# Norwich to Tilbury

**Document: 8.3.29 Draft Statement of Common Ground - SRC Group  
(Crown Quarry mineral site A79) - Tracked Changes Version**

**Final Issue C**

**June 2026**

Figure 1 Interaction between TB17 to TB20

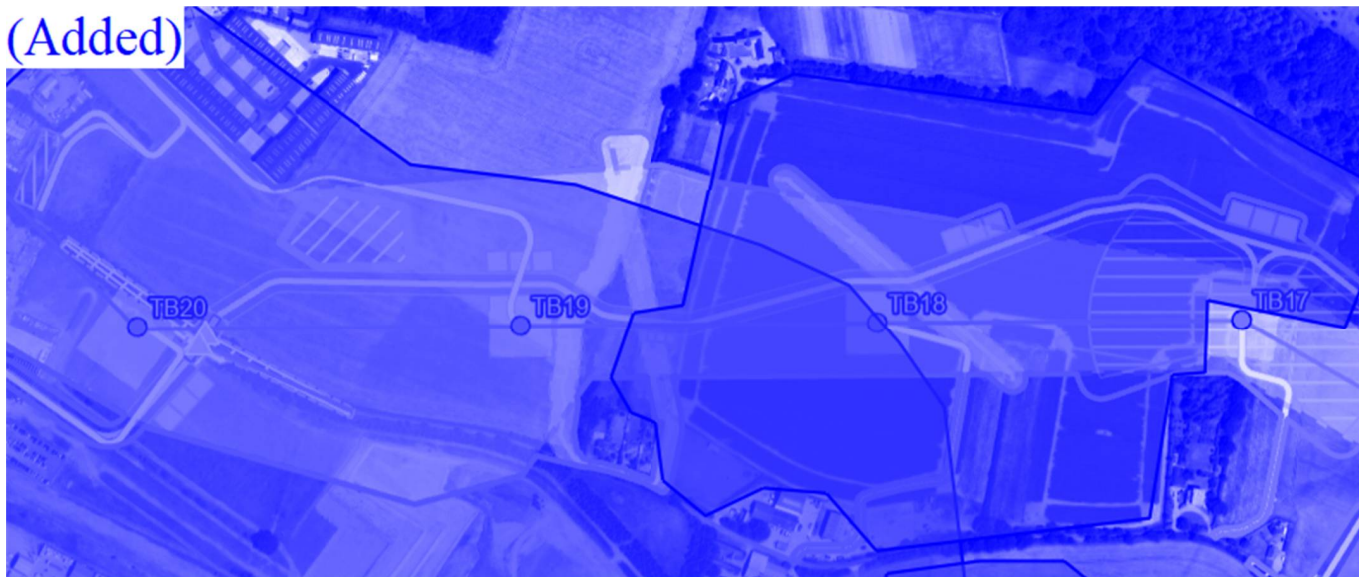
ID	Issue	National Grid Position	Stakeholder Position	Status
7.2	Permanent sterilisation of minerals under electrical infrastructure pillar of support	<p><del>National Grid anticipate</del> <u>The Applicant anticipates</u> that while there will be sterilisation of the tower areas, especially for TB18 and potentially <del>TB017</del> <u>TB17</u>, stand off areas will allow for the rest of the site to be extracted.</p> <p>SRC <del>group</del> <u>Group</u> to provide anticipated extraction areas and depths so that sterilisation could be reviewed by <del>National Grid</del> <u>the Applicant</u>.</p> <p><u>It is agreed that extraction depths have been requested and provided for Martells Mineral site by SRC Group.</u></p>	<p>Given that the information requested by SRC since 15/09/25 has not been provided SRC is not in a position whereby it can agree this. This request has only been put to SRC on 03 February 2026. Nevertheless, given that the information requested by SRC since 15/09/25 has not been provided SRC is not in a position whereby it can provide this information.</p> <p>Equally, mineral sterilisation will lead to void sterilisation and consequent impacts on recycling volumes. These impacts cannot be assessed without consideration of the information requested on 15/09/25 and since.</p> <p>The consequences may effect both the existing quarry as well as the proposed northern extension.</p> <p><u>We have only been asked to provide extraction depths for Martells (north of Frating Road) but not Crown Northern Extension. These have now been requested and provided.</u></p>	<p><u>The Applicant reviewed mitigation options in reference to pylon TB20 - the first pylon from the A12 which is situated in the existing quarry site - and are now committing to the alternative scenario to move the position of the pylon.</u></p> <p><del>SRC await the information requested at the meeting on 15 September 2025 and since.</del></p> <p><del>Following receipt of the information requested by SRC on 15 September 2025 and since, SRC is willing to provide this information once it has had the opportunity to give the matter due consideration</del></p>

ID	Issue	National Grid Position	Stakeholder Position	Status
7.3	Temporary access for construction	<p><del>National Grid acknowledge</del> <u>The Applicant acknowledges</u> that the proposals for the haul road will impact the potential for extraction at TB18 and TB17. As above, SRC <u>Group</u> to provide extraction areas for review.</p>	<p>Given that the information requested by SRC since 15/09/25 has not been provided SRC is not in a position whereby it can comment on this in a meaningful way SRC hold the reasonable opinion that the consequences of any temporary accesses</p>	<p><del>Following receipt of the information requested by SRC on 15-September 2025 and since, SRC is willing to provide this information once it has had the opportunity to give the matter due consideration</del> <del>Following receipt of the information requested by SRC on 15-September 2025 and since, SRC is willing to consider this matter further</del> <u>This commitment was confirmed in Table 2.4 of 8.11 Approach to Scenarios [REP4-310].</u> <u>The Applicant reviewed mitigation options in reference to pylon TB20 - the first pylon from the A12 which is situated in the existing quarry site -</u></p>

ID	Issue	National Grid Position	Stakeholder Position	Status
		<p><u>It is noted that the haul road has the potential to result in mineral and void sterilisation. However, the haul road is temporary in nature and, once removed, the underlying mineral can be extracted, thereby minimising any long-term sterilisation impacts, including those relating to recycling.</u></p> <p><u>With regard to routing, the Applicant acknowledges that a haul road alignment south of TB20 is not feasible, including due to its interaction with existing infrastructure. The Applicant is therefore progressing consideration of alternative routing to the north and will provide further detail on this in due course.</u></p>	<p>for construction are not limited solely to TB17 and TB18 but to the whole for the route as it interacts with SRC's holdings.</p> <p>In particular, proposals for access off Old Ipswich Road as set out prior to the meeting of 15/09/25 will lead to the closure of the quarry, its extension, the recycling, the industrial units and will prevent the construction and use of the proposed asphalt plant</p> <p><u>Haul road has the potential to cause significant mineral sterilisation as well as void sterilisation with consequential impacts on recycling.</u></p> <p><u>As above, we have only been requested to provide mineral depth information for land north of Frating Road at Martells.</u></p> <p><u>Confirmation is needed on the 'alternative route'.</u></p> <p><u>Pleased to see acknowledgement that the haul road south of TB20 is 'not viable'.</u></p>	<p><u>and are now committing to the alternative scenario to move the position of the pylon.</u></p> <p><del>Following receipt of the information requested by SRC on 15-September-2025 and since, SRC is willing to provide this information once it has had the opportunity to give the matter due consideration</del></p> <p><del>Following receipt of the information requested by SRC on 15-September-2025 and since, SRC is willing to consider the implications further and advise NG accordingly. This commitment was confirmed in Table 2.4 of 8.11 Approach to Scenarios [REP4-310].</del></p>

ID	Issue	National Grid Position	Stakeholder Position	Status
7.4	Oversail of Minerals Sites	<p><del>National Grid</del> <u>The Applicant</u> anticipates that mineral extraction can be carried out under the overhead line but will confirm clearances.</p> <p><u>It is acknowledged that there may be a potential interaction between the timing of haul road construction and the programme for the overhead towers. The Applicant is continuing to consider construction sequencing to ensure that the haul road can be delivered in a timely manner to support the works, while minimising any sterilisation impacts. Further detail on the proposed programme and phasing will be provided to SRC Group as it is refined.</u></p>	<p>This is helpful to know however the information requested by SRC since 15/09/25 has not been provided SRC is not in a position whereby it can comment on this in a meaningful way.</p> <p><u>This may be at odds with the timescales and need to construct a haul road in advance of constructing the overhead towers.</u></p>	<p><del>Following receipt of the information requested by SRC on 15 September 2025 and since, SRC is willing to give this matter further consideration</del> <u>Discussion s ongoing.</u></p>

ID	Issue	National Grid Position	Stakeholder Position	Status
		<p><del>discussions fail to proceed.</del></p> <p><u>It is noted that the access routes shown may be interpreted as permanent roads with the potential to result in mineral and void sterilisation, as well as implications for restoration. However, the Applicant clarifies that the “permanent access” refers to a defined route for occasional maintenance access to the infrastructure. This access would not be required until after completion of the construction phase. The Applicant anticipates that mineral extraction within this area will have been completed by that stage, thereby avoiding any prejudice to the approved restoration scheme or giving rise to sterilisation concerns.</u></p> <p><del>The Applicant requires continuous access for maintenance, with a defined DCO route.</del> <u>The Applicant notes the suggestion regarding access from the north via Wick Lane. However, TB20 is proposed to be relocated further north, and the associated access arrangements are currently under review and are likely to be amended accordingly.</u></p>	<p>construction and use of the proposed asphalt plant. The need for Permanent Operational Access may be at odds with NG’s statements in respect of Oversail.</p> <p><u>Assuming the screenshots below are showing permanent access routes, these have the potential to cause mineral and void sterilisation and prejudice the proposed restoration for the existing quarry. If TB20 remains, it appears access would be easier from the north via Wick Lane as opposed to through the existing quarry given that the DCO already proposes an access point adjacent to TB20.</u></p>
